SSD-13166280 – Blind Creek Solar Farm – LOT: 17 DP: 535180, LOT: 1 DP: 456698 – 114 Currandooley Road, LAKE GEORGE

Transport for NSW (TfNSW) is responding to the SSD-13166280 referred on 18 November 2022.

TfNSW has reviewed the information and is unable to properly assess possible impacts of the proposed development on the State Road network and its users and does not support the proposed development in its current form. Details of additional required information are set out in Attachment 1.

### Proposed Intersection Design

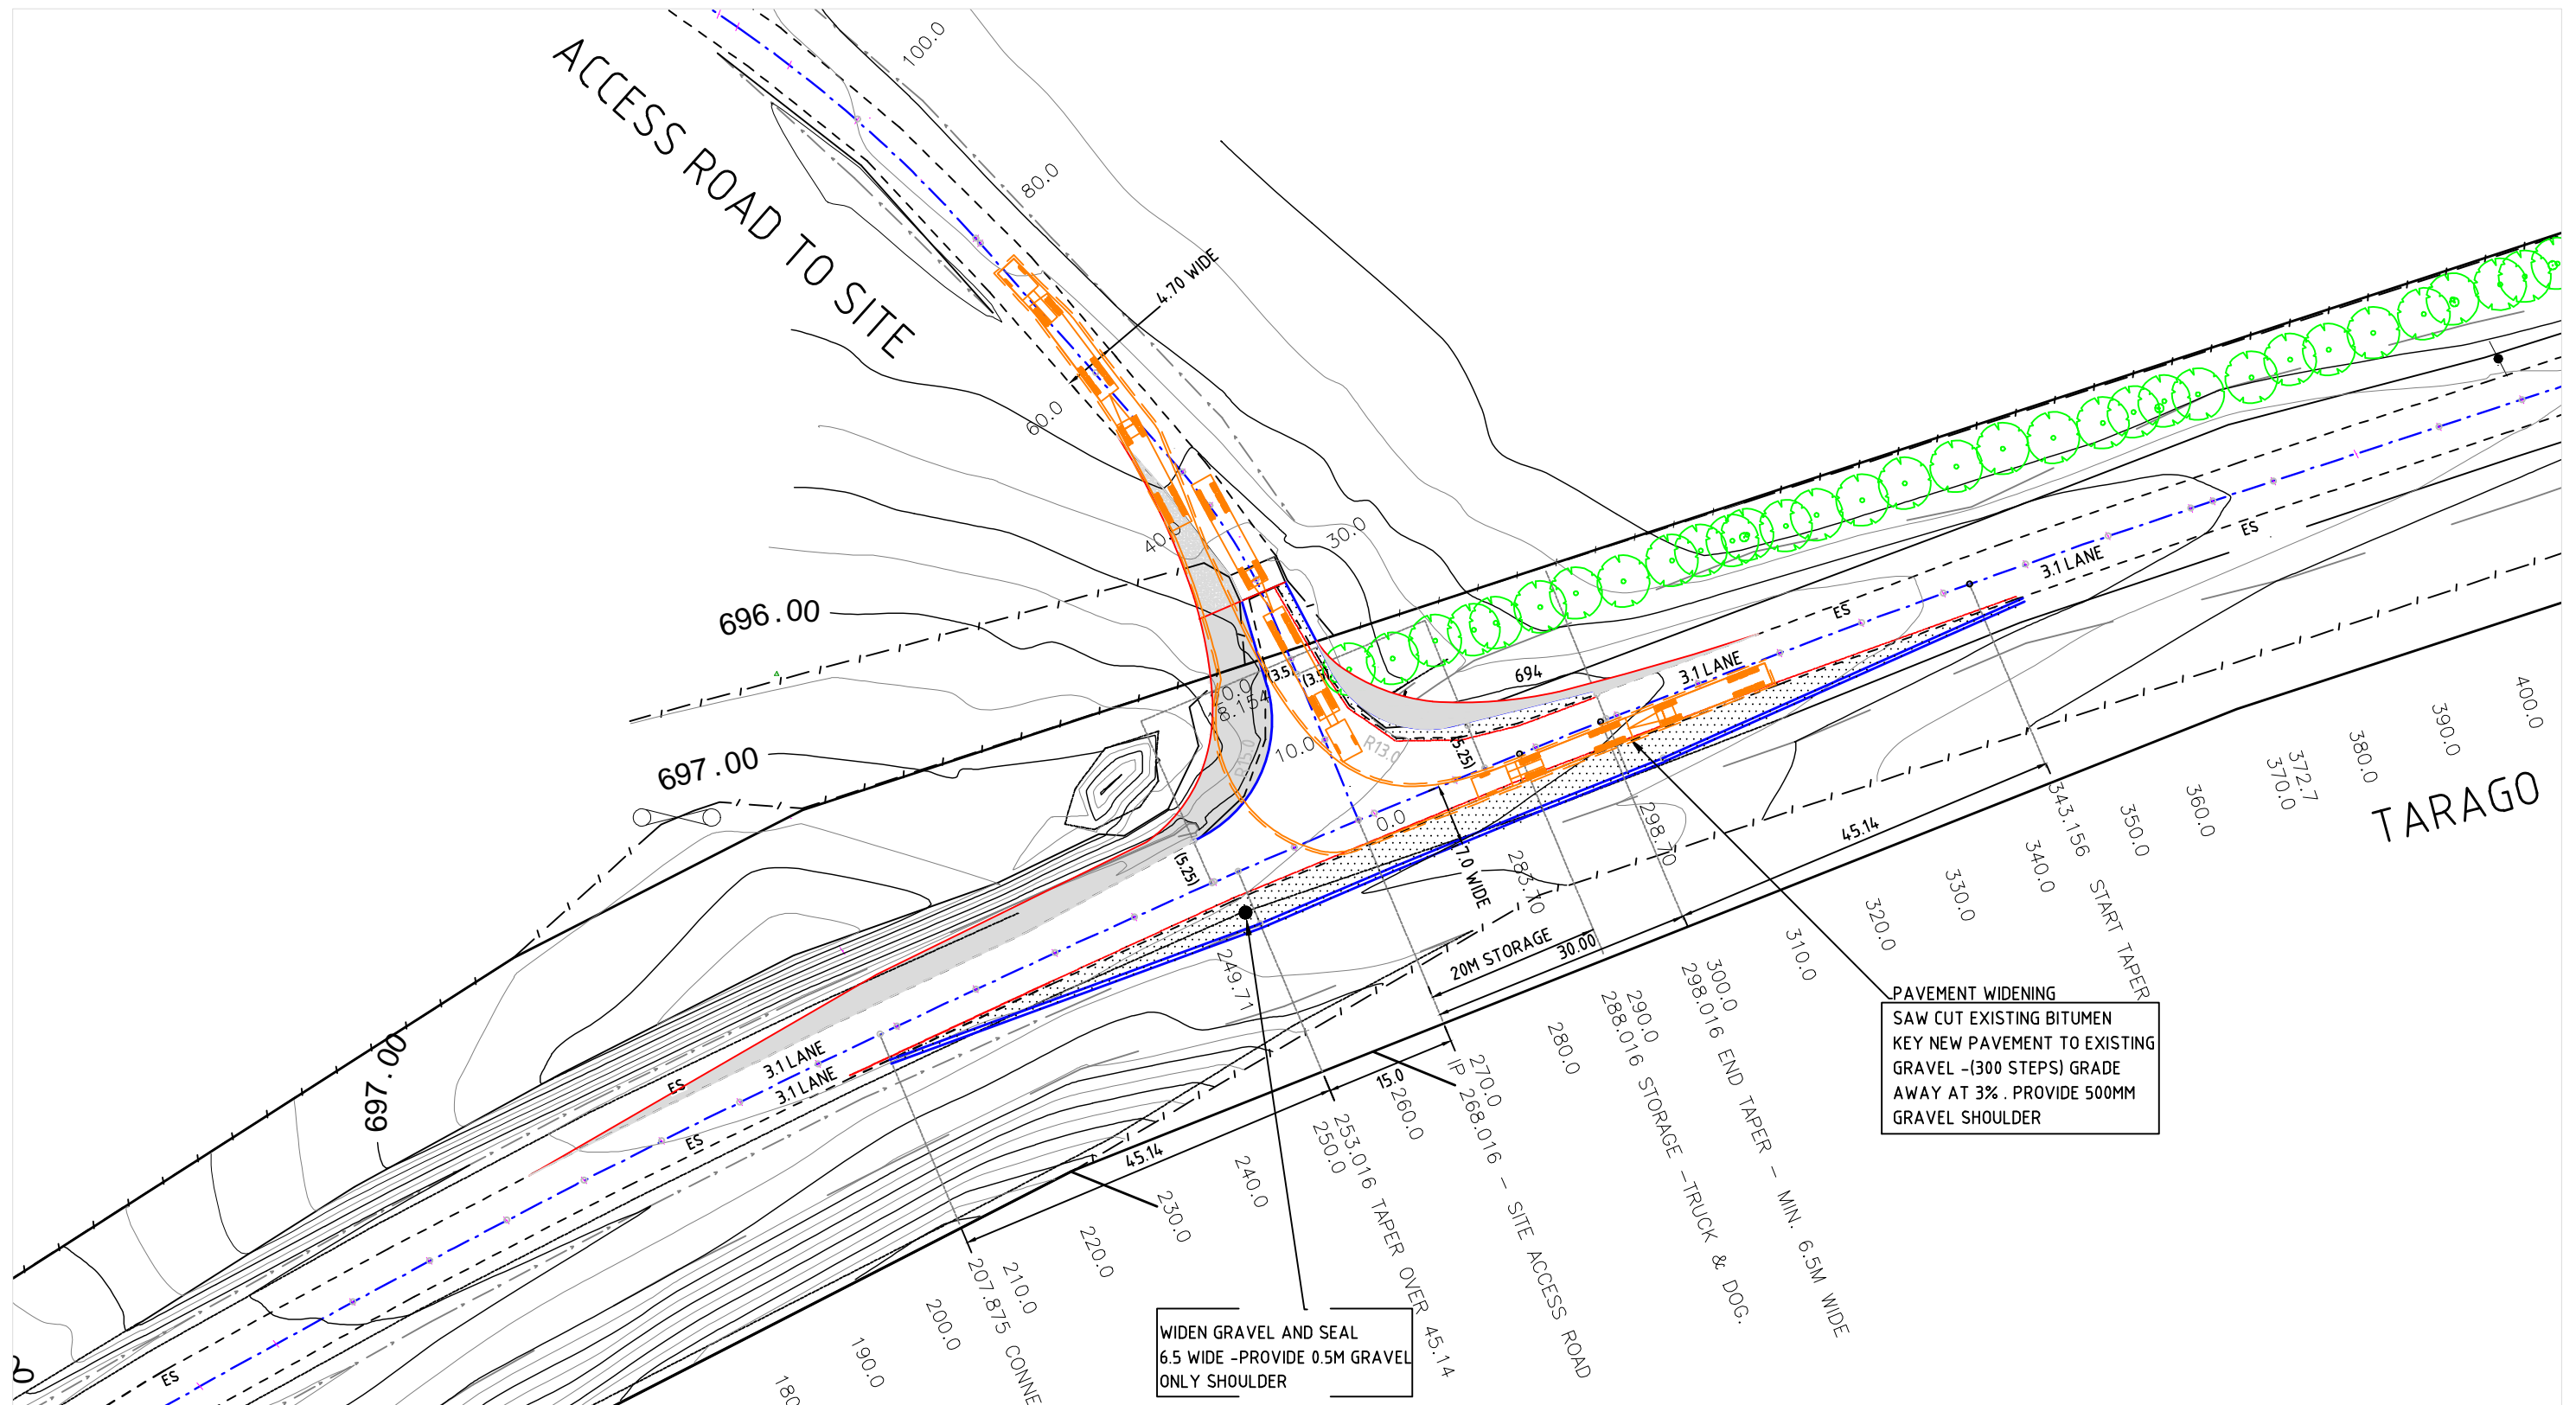
- The left-hand side table drain shape does not comply with AGRD Part 3 Section 4.6.1. The side slope should not be steeper than 4 to 1 and the batter slope should be 2 to 1. "V" shaped drains are undesirable as they tend to be susceptible to erosion. The right-hand side table drain should be graded to ensure no water will pond in the drain.
- The proposed stormwater culvert under the access should be located such that the headwalls are outside the clear zone. If the headwalls are located within the clear zone, they must be tapered concrete median headwalls (see TfNSW Standard Drawing R0210-25).

### OSOM Swept Path Assessment

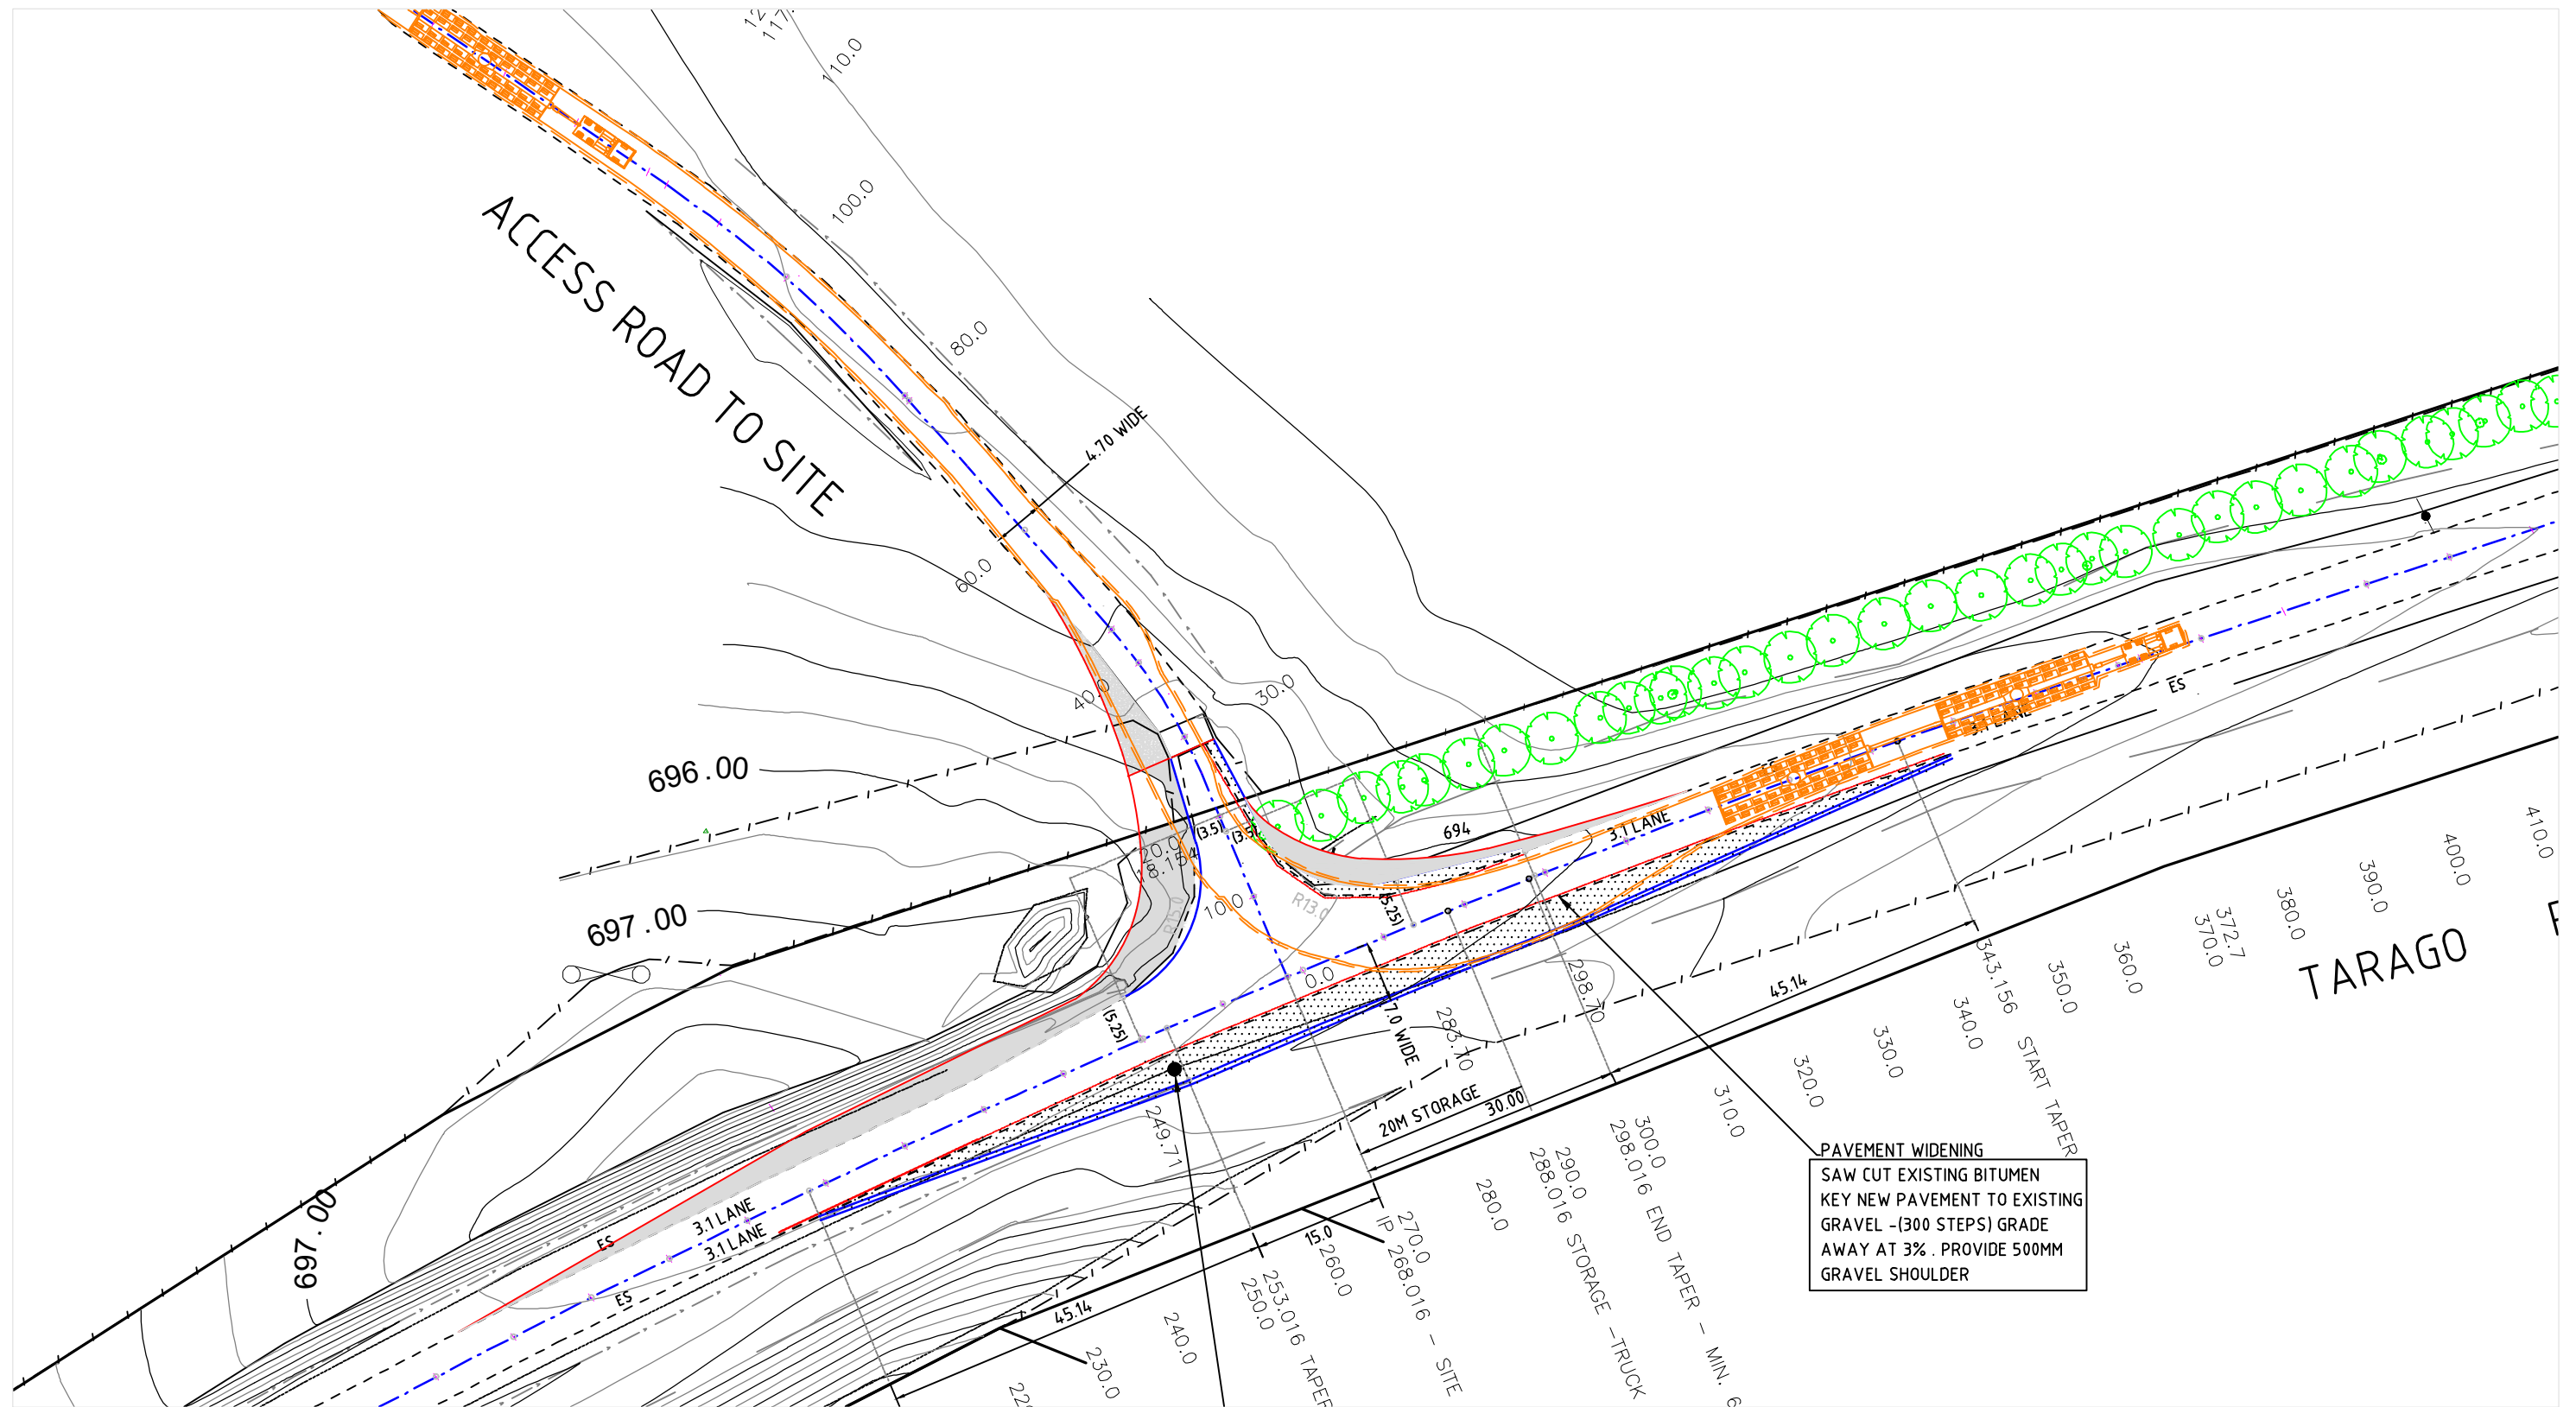
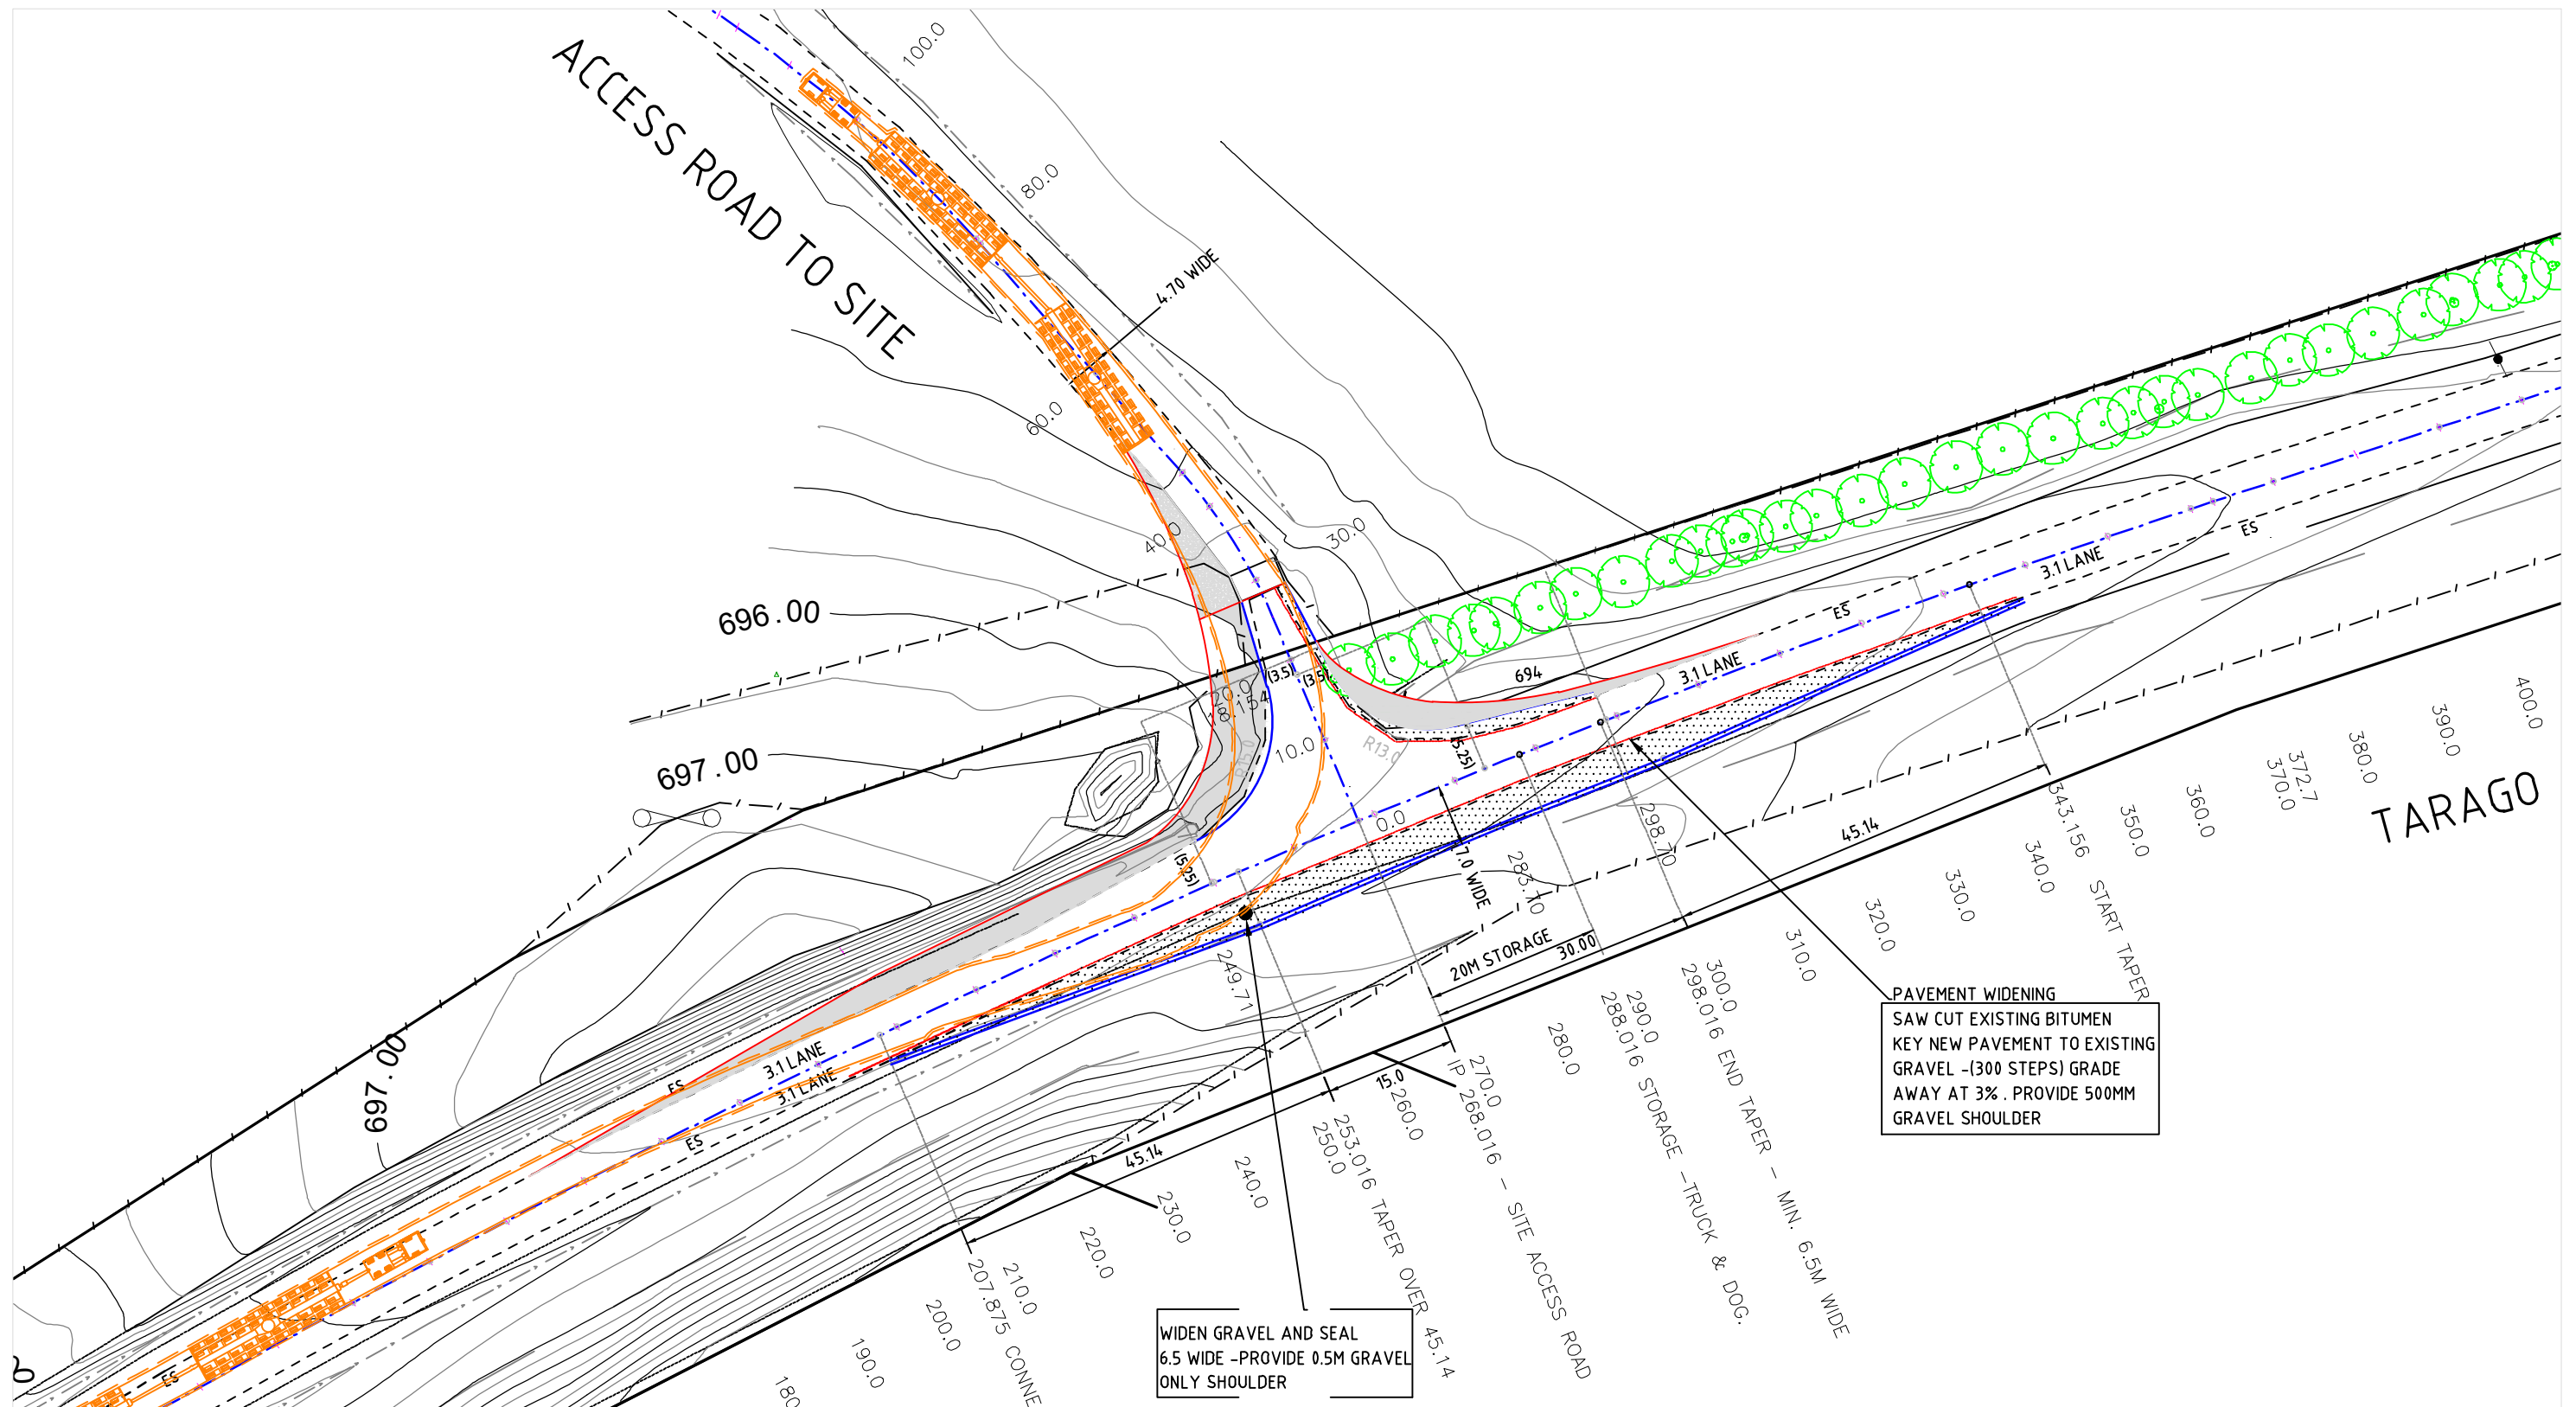
- Oversized and B-Double vehicles: Details are required on any B-Double and OSOM movements associated with the proposal as well as details on the route these vehicles will take (including a route map and swept paths of the relevant intersections) and any changes to the road network required to cater for B-Double and OSOM movements (e.g., removal of infrastructure, widening works, vegetation removal, etc).
